Rezoning Petition Review

Date of Review: December 29, 2020 (***Revised February 16, 2021***)

Rezoning Petition #: 20-200

Proposed Zoning: UR-2 (CD)

RZ-1.0

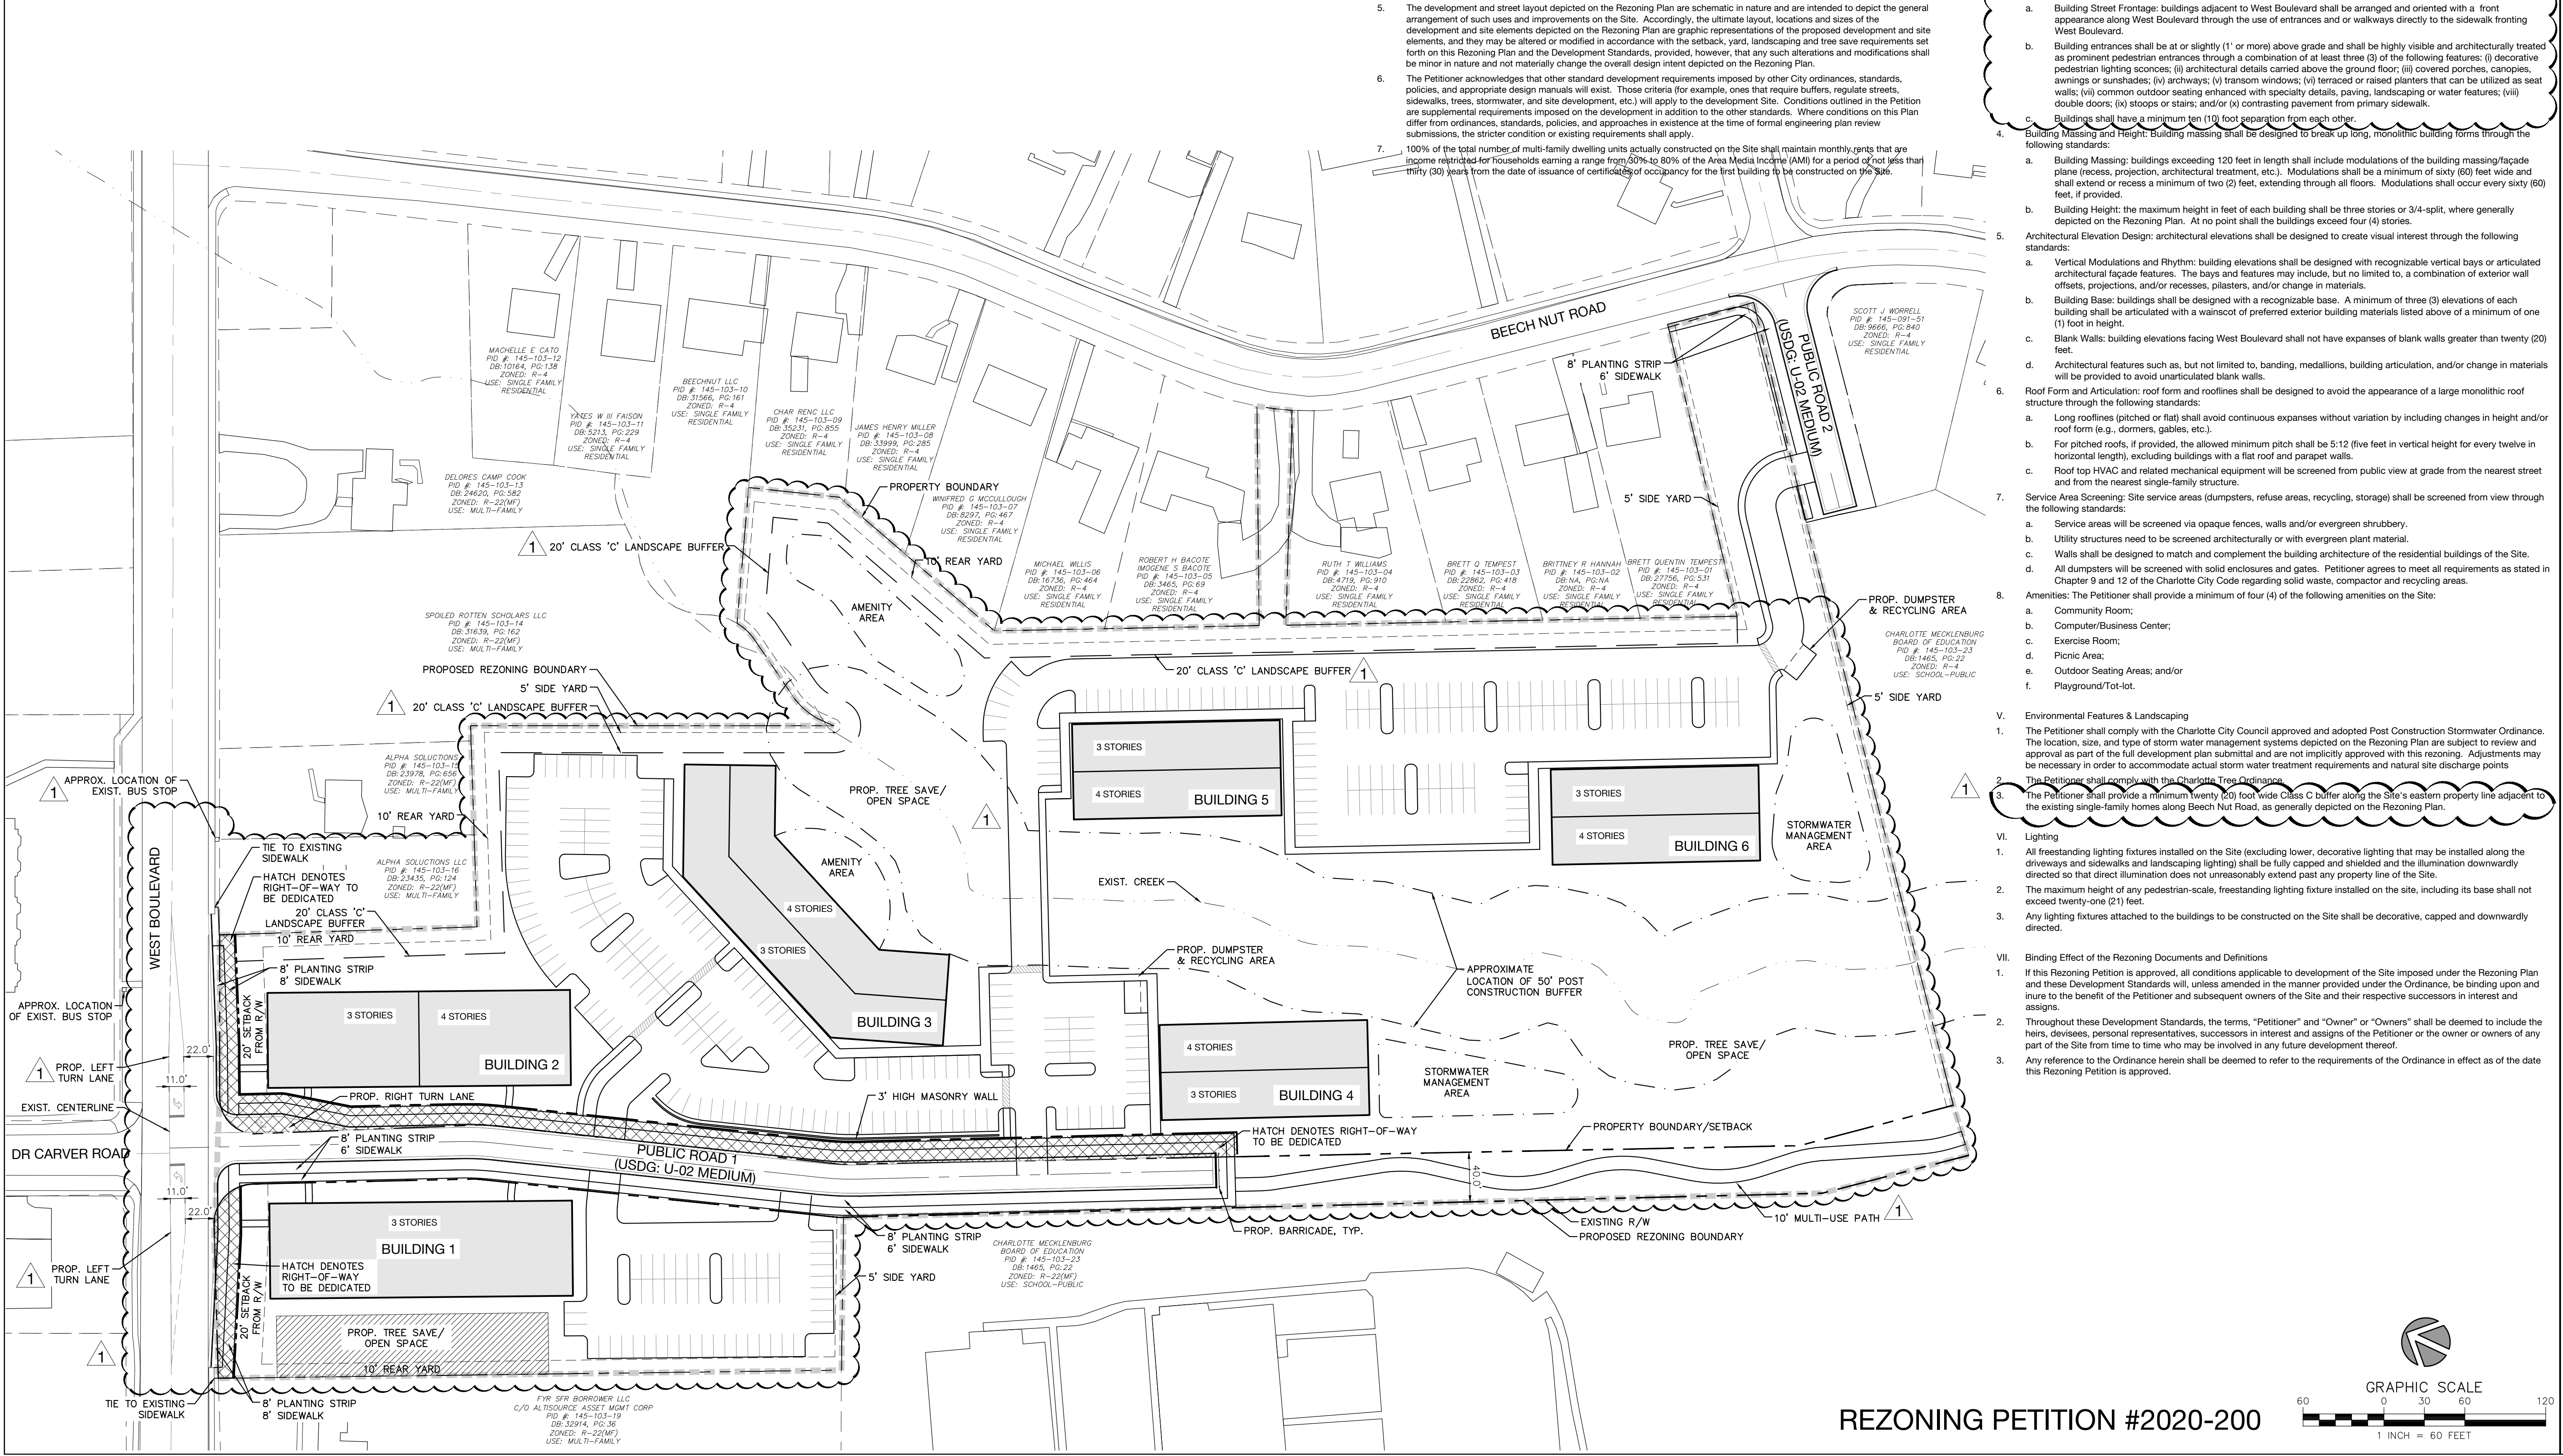
Due to revisions (1/19/21): The revised site plan indicates potential encroachments into the SWIM/PCSO Buffer. Please add the following notes under *Environmental Features*:

- *Development within any SWIM/PCSO Buffer shall be coordinated with and subject to approval by Charlotte-Mecklenburg Storm Water Services and mitigated if required by City ordinance. Petitioner acknowledges intermittent/perennial stream delineation reports are subject to review and approval upon submission of development plans for permitting and are not approved with rezoning decisions.*

Due to revisions (2/16/21): No additional recommendations are needed at this time. Proposed SWIM/PCSO Buffer encroachments were removed from the rezoning plan sheet.
